Reference No:	2023/62/93151/E
Site Address:	22, Crowlees Road, Mirfield, WF14 9PJ
Description:	Erection of an additional storey to the existing dwelling, hip to gable extension, roof extension and rear extension with external alterations.
Recommending Officer:	Edward Cheseldine

DECISION – CONDITIONAL FULL PERMISSION

Officer Report

2023/93151 - 22, Crowlees Road, Mirfield, WF14 9PJ

TITLE
PROPOSED GA PLANS

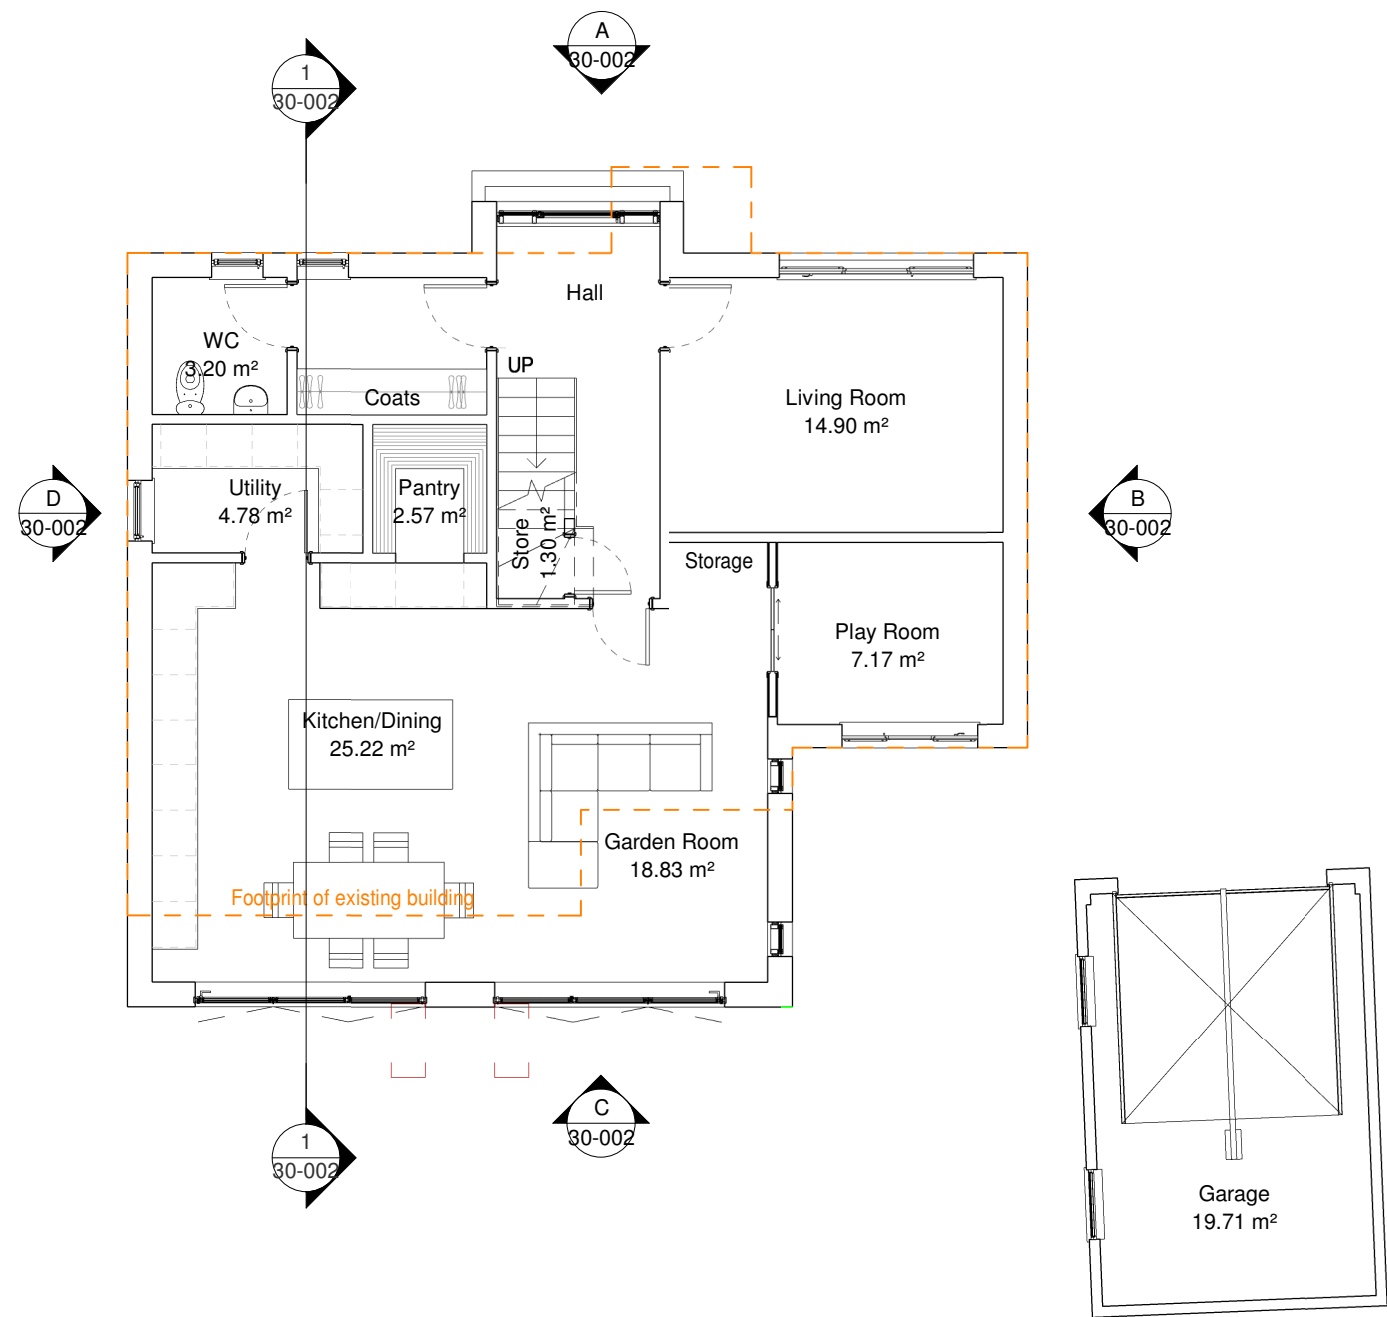
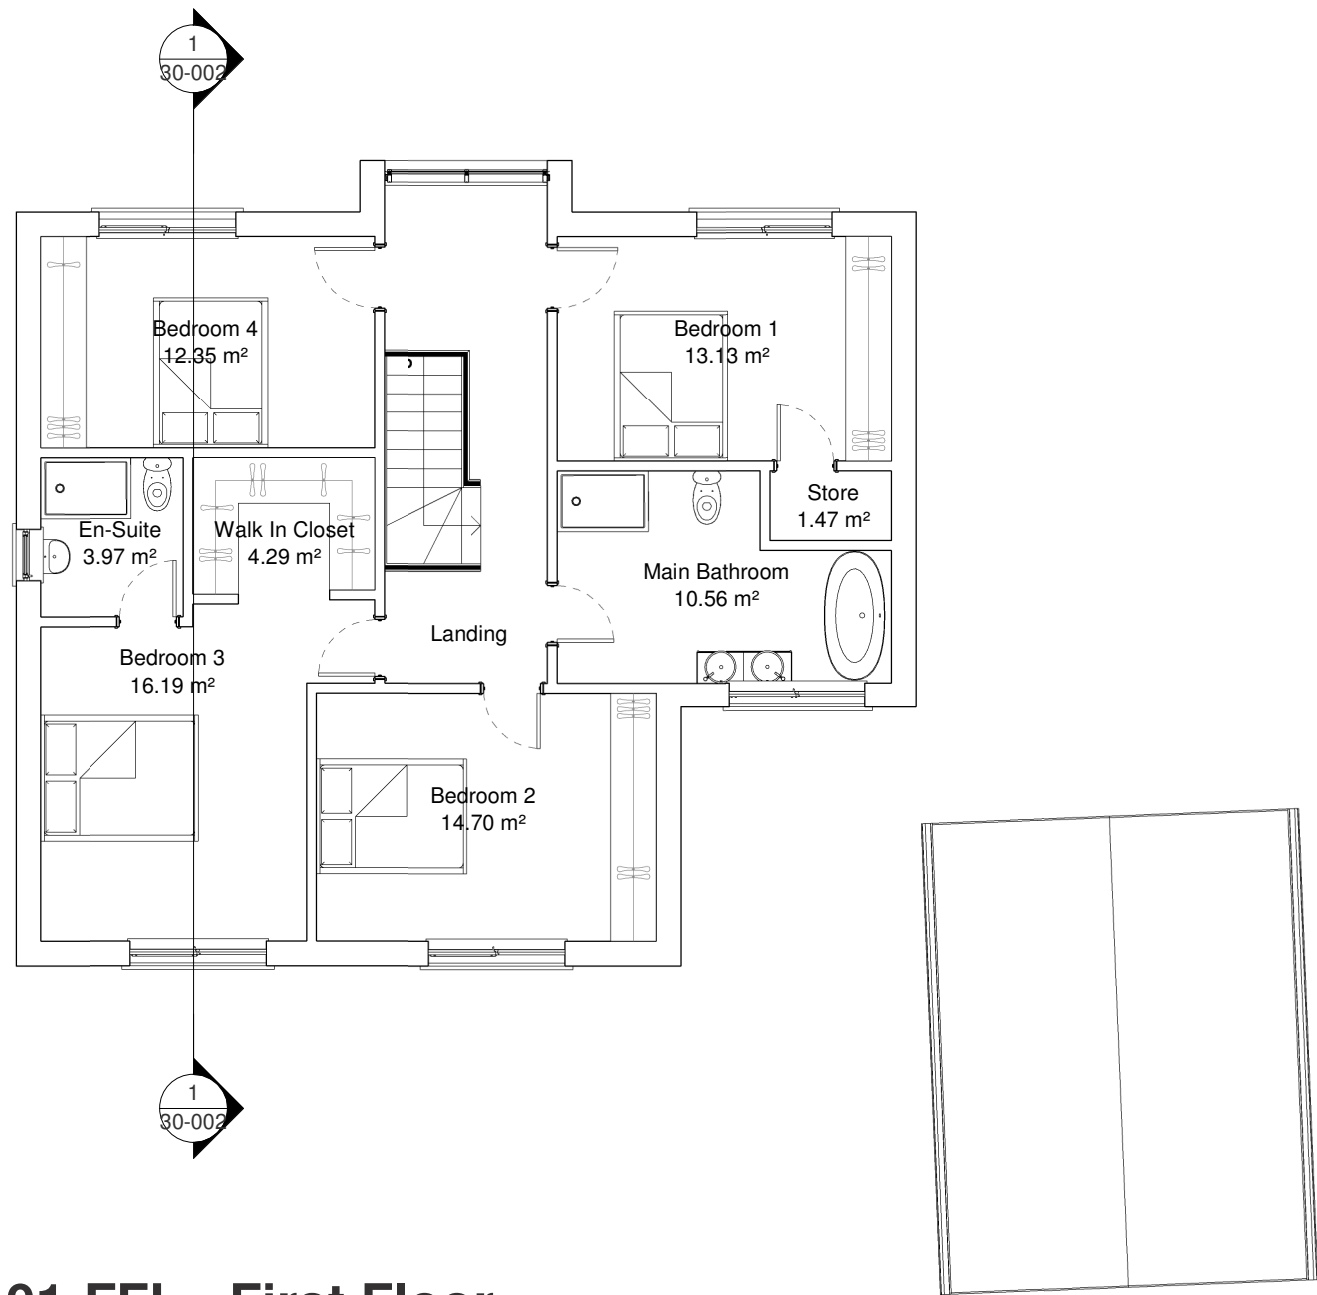
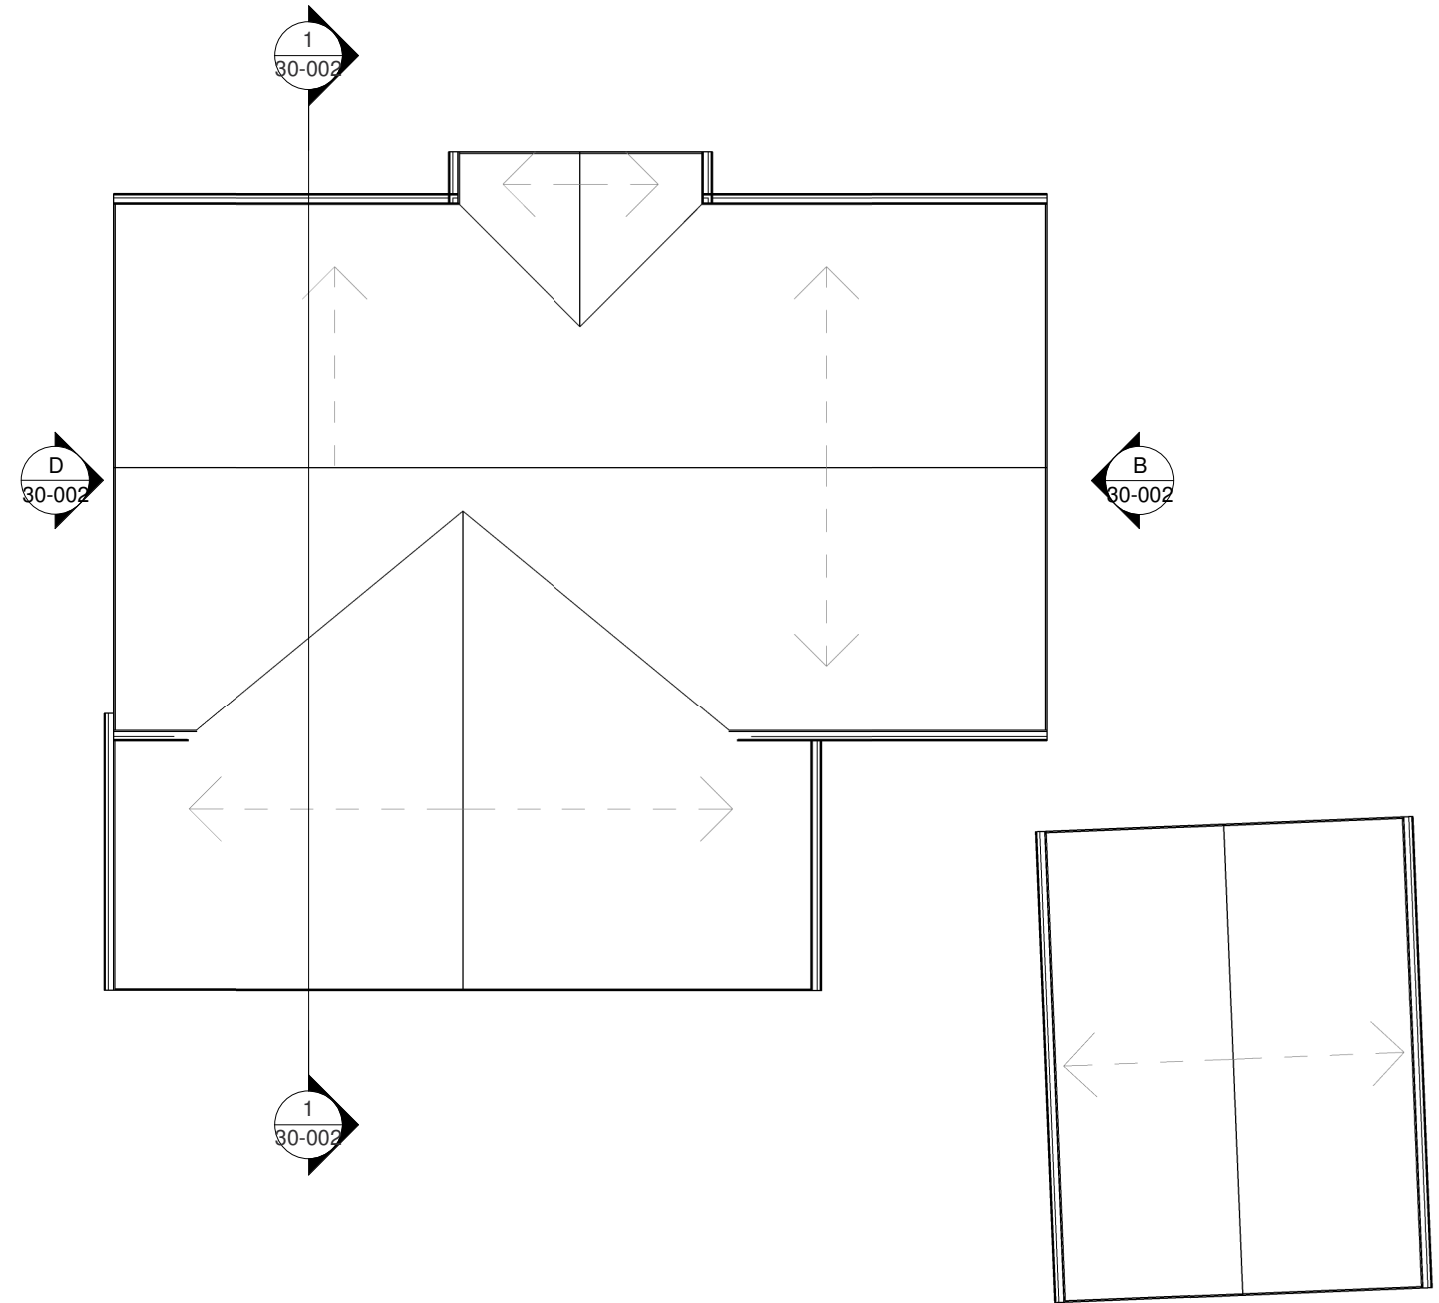
rear of the property, as Crowlees Road is a residential area, the impact of the additional massing has been considered by the Planning Officer. Amendments have been made to the original proposal to reduce the height of the ridgeline of the rearward roof projection.

As the first-floor window serves an en-suite, it will be conditioned that this window is obscurely glazed to maintain privacy levels. In addition to the windows to the side, there will be newly formed windows to the rear of the property. Consideration has been given to for the Lawful Development Certificate that has been granted in ref: 2023/92478 for the erection of an

2. The development shall not be occupied until the windows of the areas marked W/C & ensuite on drawing No. 30-002-A of the building hereby approved have been obscurely glazed (to a minimum Grade 4). Notwithstanding the provisions of the Town and Country Planning (General Permitted Development) Order 2015 as amended (or any Order revoking or re-enacting that Order) the obscure glazing (to a Grade 4) shall thereafter be retained.
